Application No: FG/52/22/HH
Site Address: 6 Beehive Lane Ferring BN12 5NL
Description of works: Erection of two storey front extension with front canopy, single storey side and rear extension and extension of loft to habitable use including the installation of 1 x side dormer.

Thank you for your internet representation made on 18th April 2022 which has been recorded as an objection with the comments as follows:

Drawing
Proposed Elevations

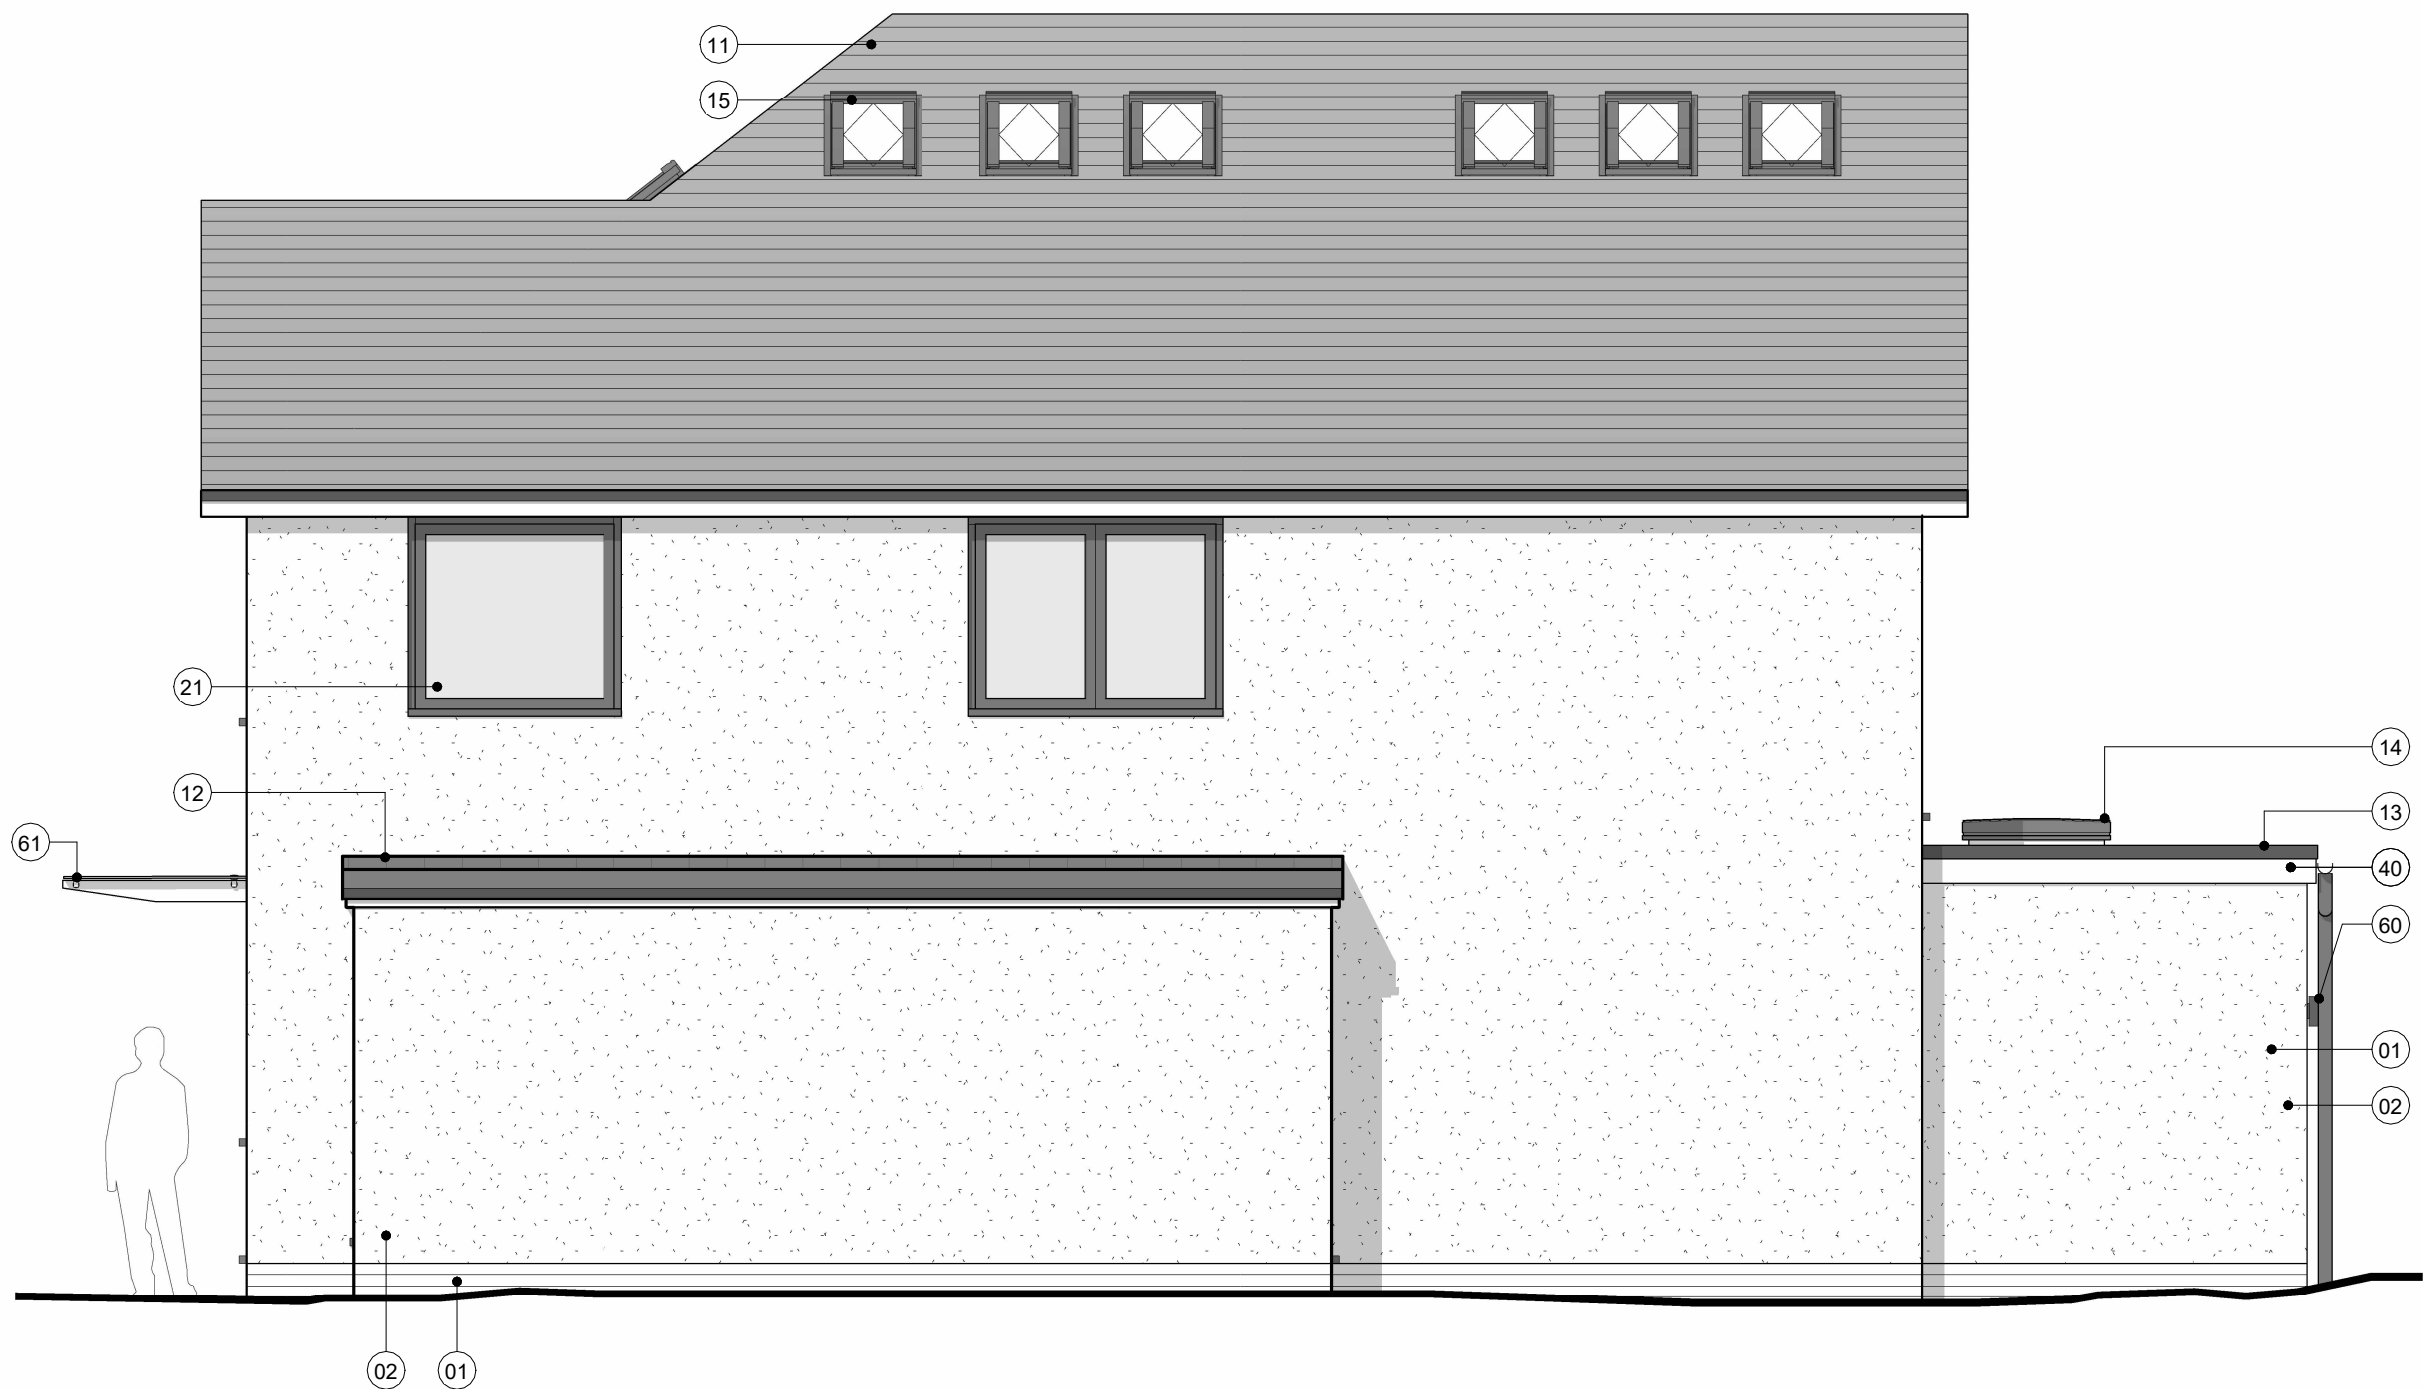
There is no place in this locality for what will be an overpowering three storey building.

There is already an obtrusive addition on the third floor of the property which is incongruous and further additions will be out of all proportion as well as impinging on the privacy of adjacent neighbours.

If the application is approved, the area surrounding the proposed development would be seriously affected. It would also set a precedent for 3 storey.
